**M5 Junction 10 Improvements Scheme- proposed Development Consent Order  
Interested Party Reference No. M510-AFP046**

I submit the following written representations, on behalf of my clients, the landowners of the farm land adjoining the A4019 known as land at [REDACTED] - Mrs Mary Bruton & Ms Elizabeth Counsell. This follows my presentation to the Inspectors at the Inquiry hearing on 16<sup>th</sup> October 2024.

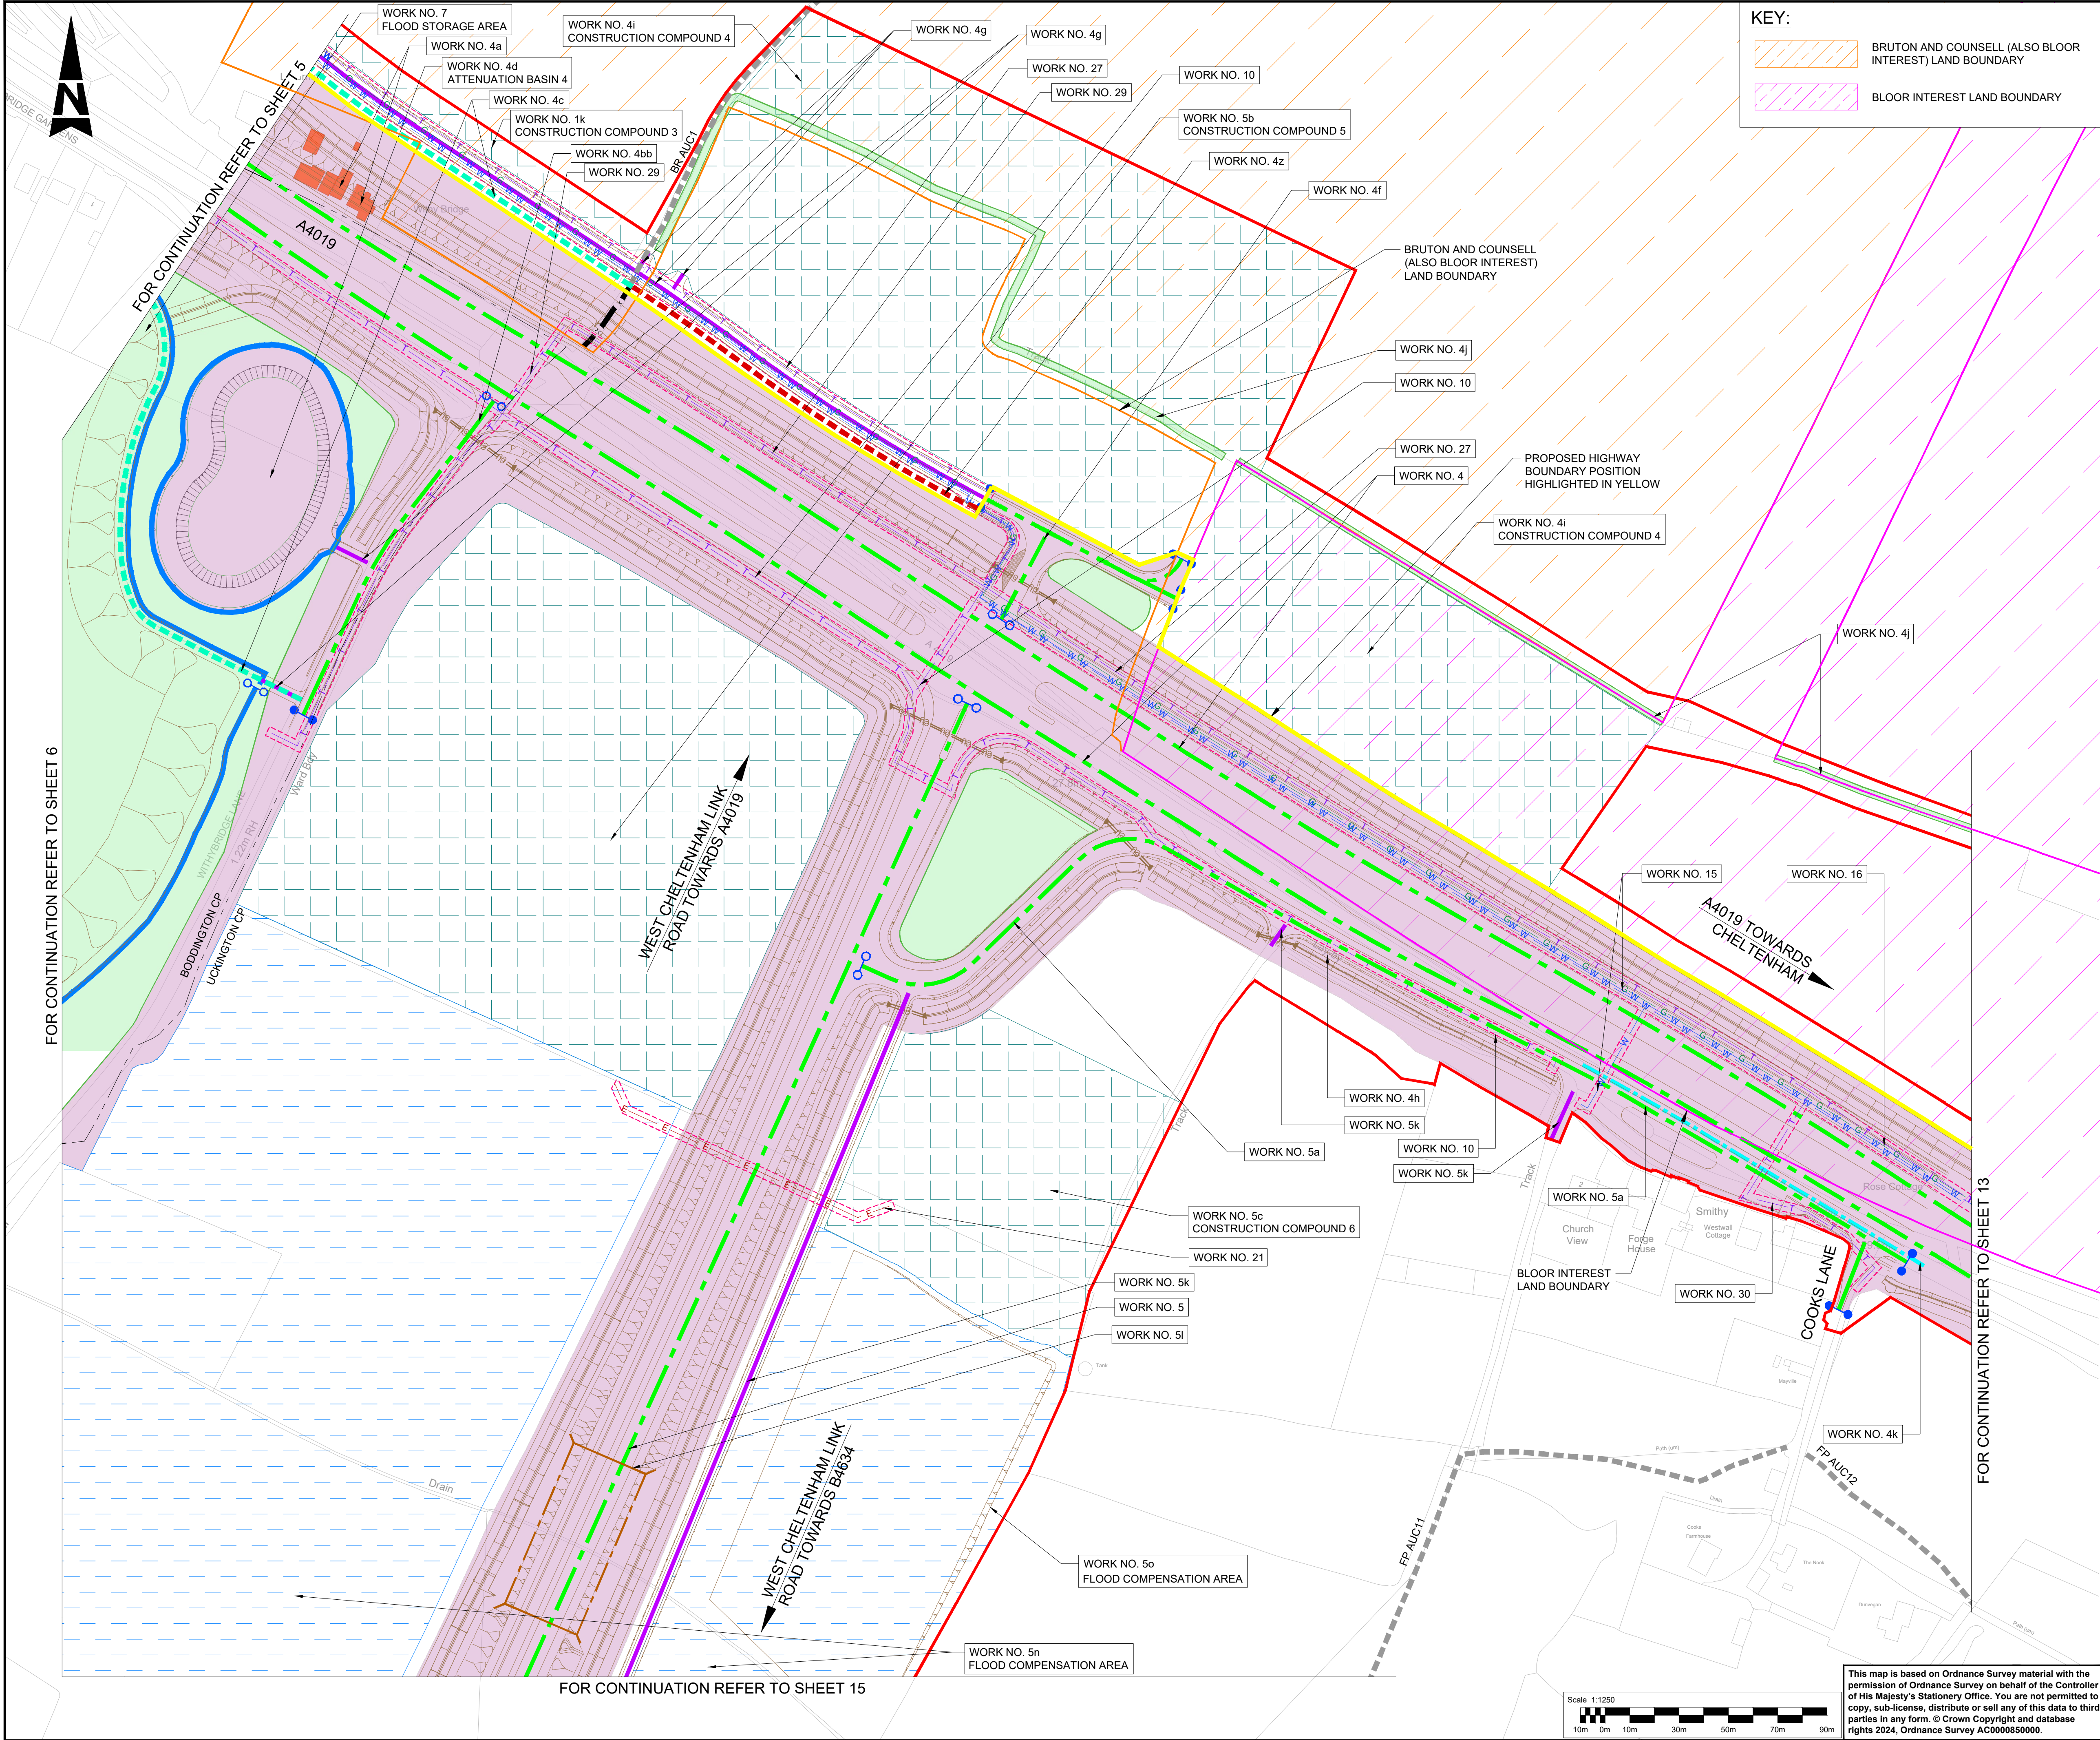
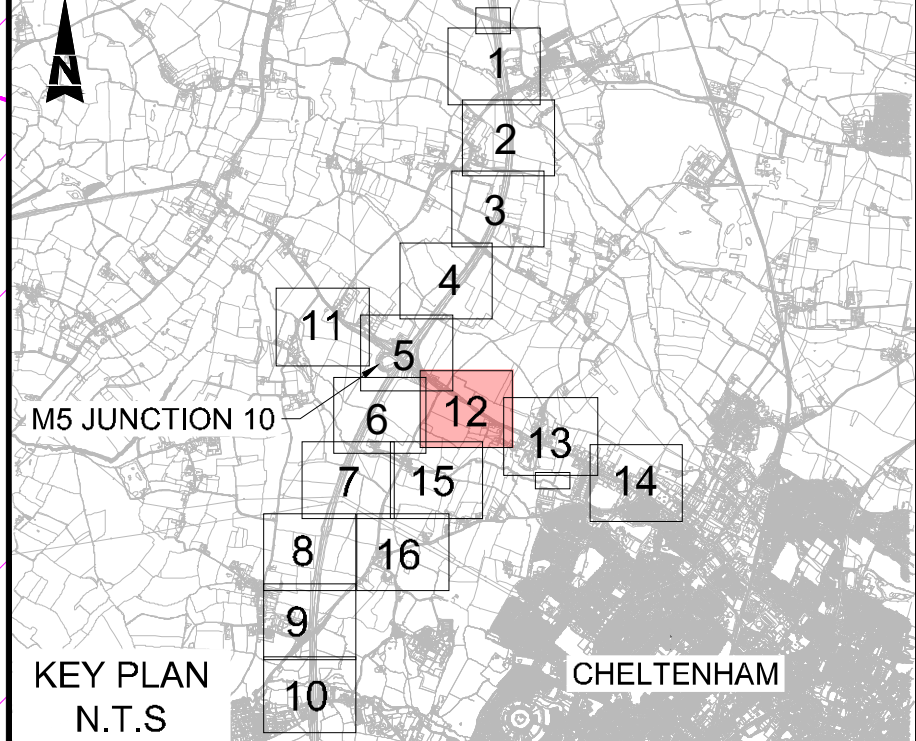
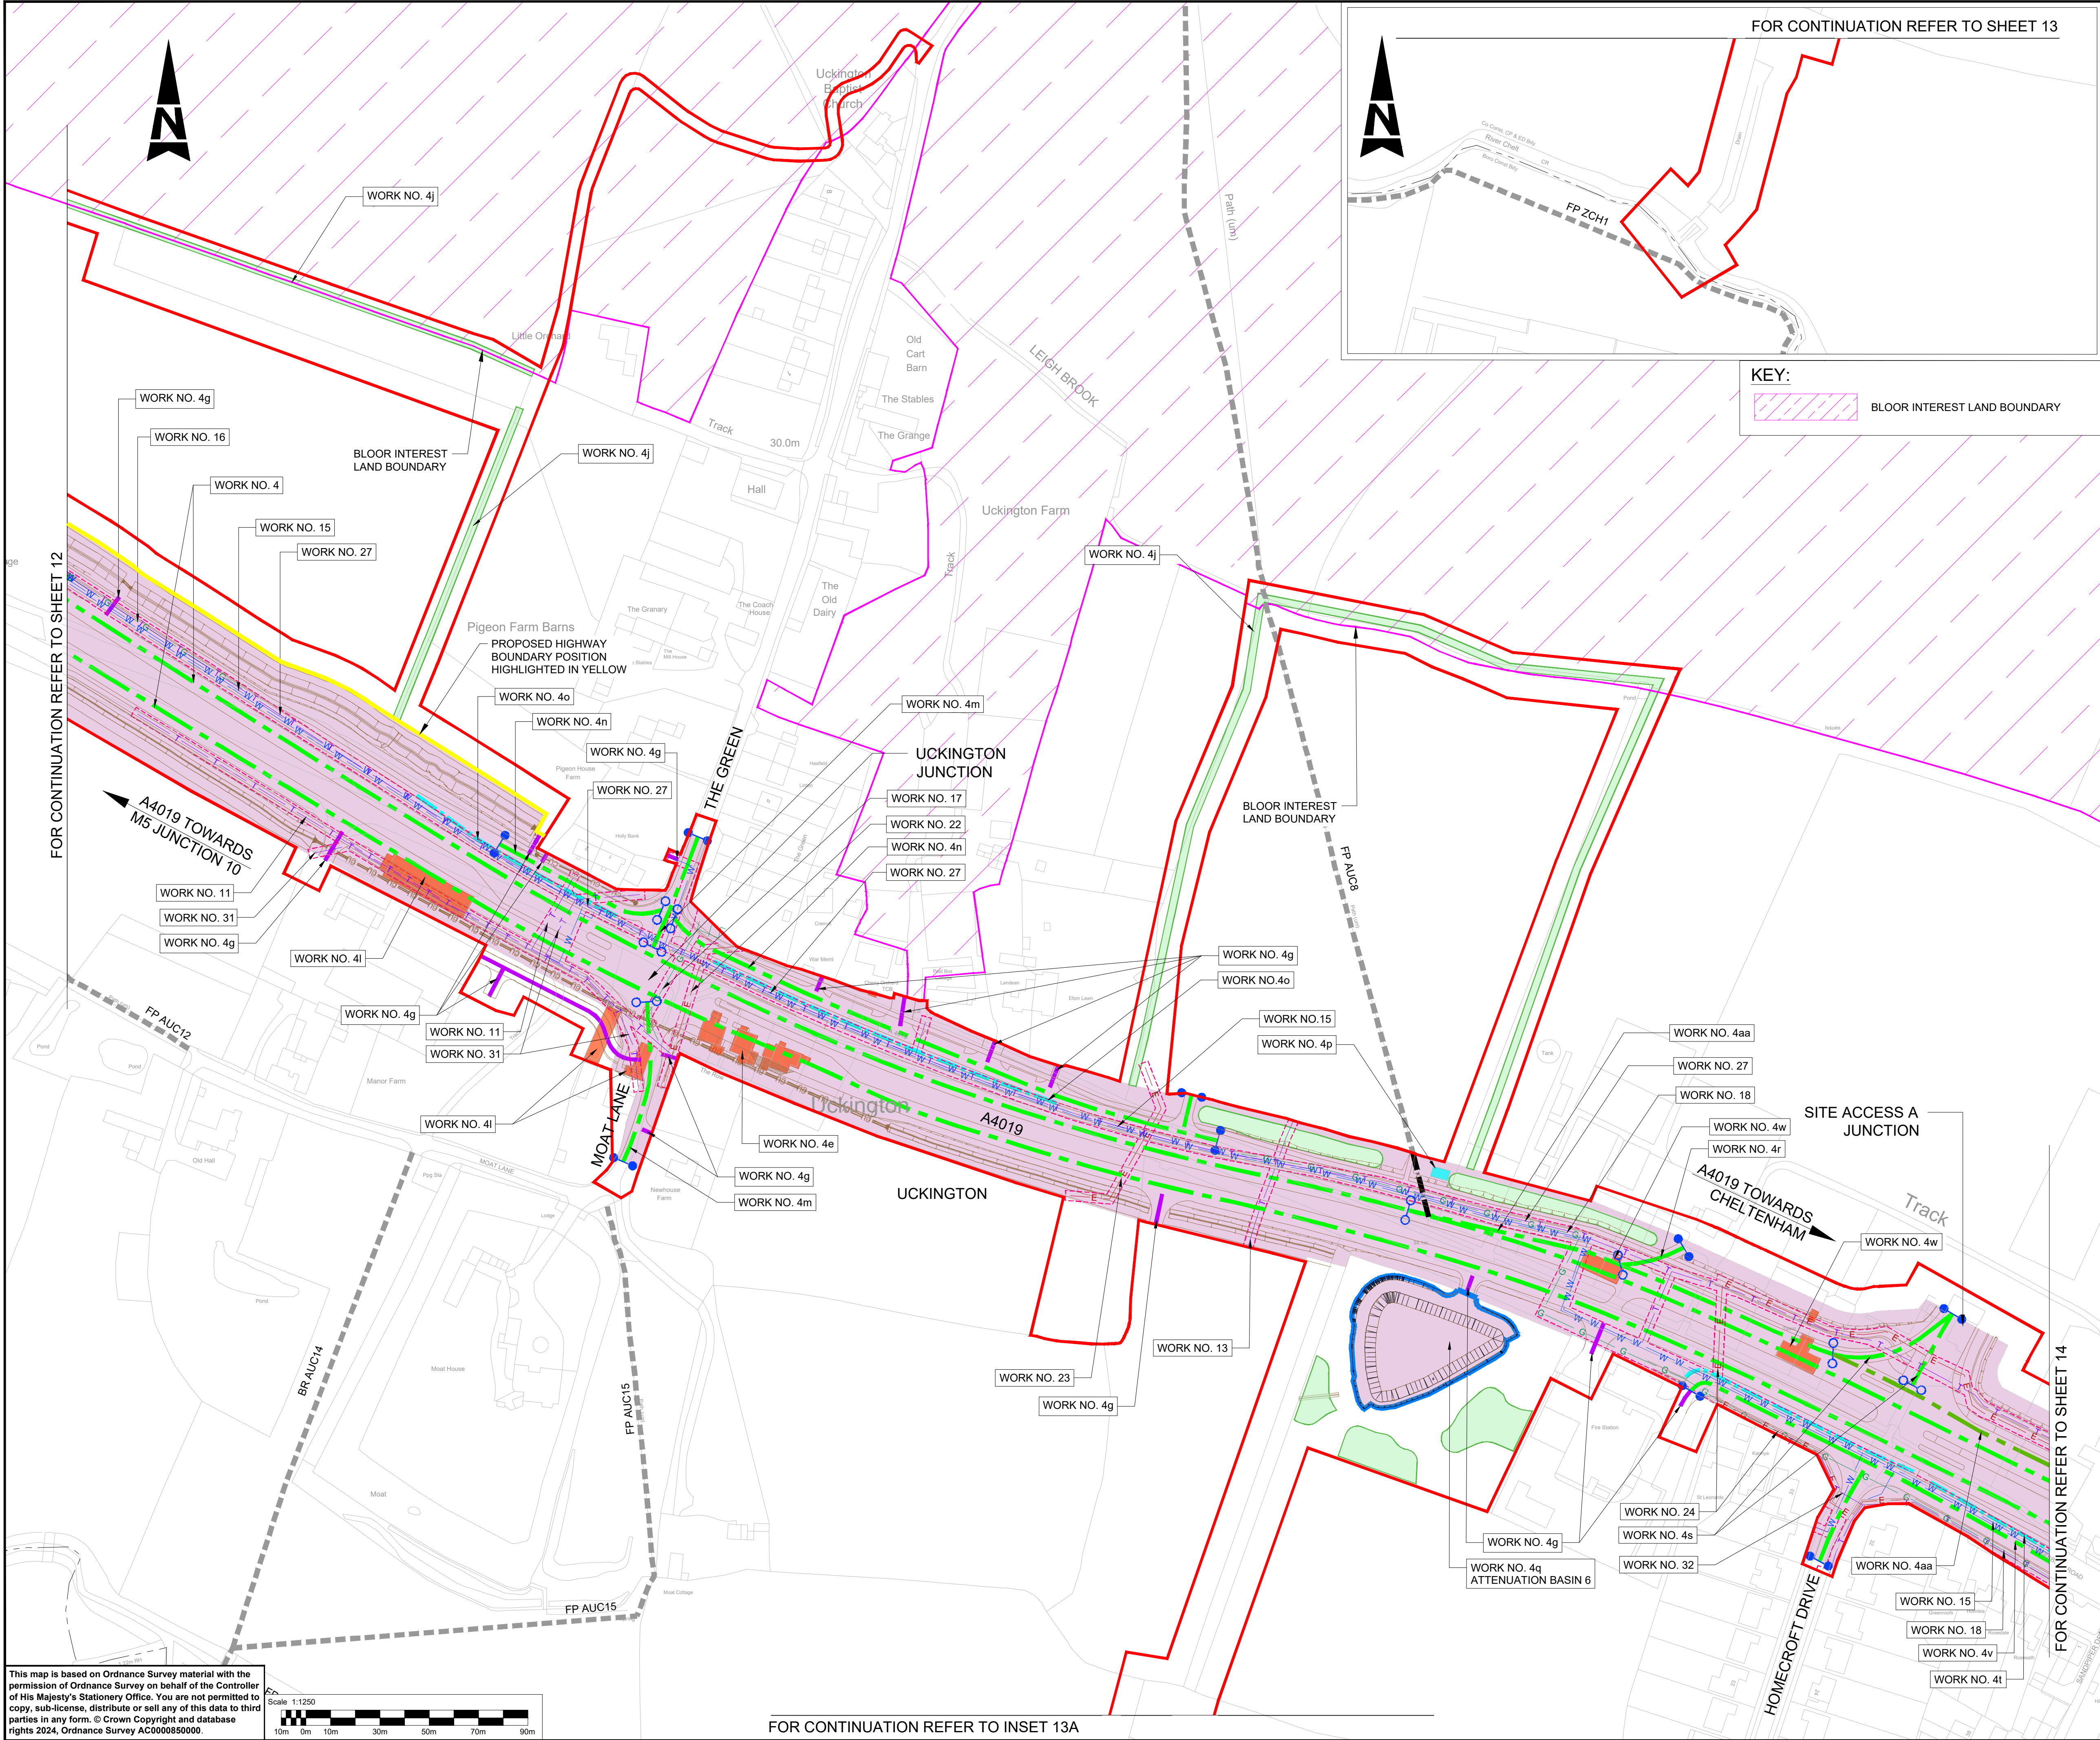
**1. Proposed shared farm access track**

My clients have safety concerns at the risks that the proposed access creates for large, slow farm machinery entering their land from an already busy road during peak periods, as well as capacity issues for exit flows.

The proposed shared track will serve at least five landowners, plus Highways England. At peak times such as harvest, this will create conflicts between landowners due to the bends of the service roads and road splays that are proposed as part of the scheme, which could impede traffic entering and exiting the junction with resultant tailbacks towards the M5.

My clients take their straw away on articulated 40 feet (12.2m) long trailers that, when the tractor and dolly draw bar are added, gives a combined length of 20.7metres; these articulated trailers cut corners when turning and we are not convinced that the five metre width (plus two metres of stoned edge and extended track bends) will be nearly enough given the double 90 degree turns off the A4019 and then almost immediately on to the access track, followed again by the 90 degree turn in to the fields. There is also the combined harvester front table that with its trailer will be at least 16.7m plus tractor with front weights 6.5m, thus 23.2metres. The swept path analysis by the applicants is only for vehicles that are 19.02m and the drawing's chosen tractor with bale trailer is not an articulated trailer. My client has particularly instructed me to point out that when exiting the land with large rectangular bales stacked three high and making a sharp turn the trailer is at its most unstable and sufficient level turning width is essential. The width of the track when vehicles are travelling in a straight line is not a problem, it is the turns that are the issue and there is no detail of a wide and suitable swept access in to my clients' main field entrance.
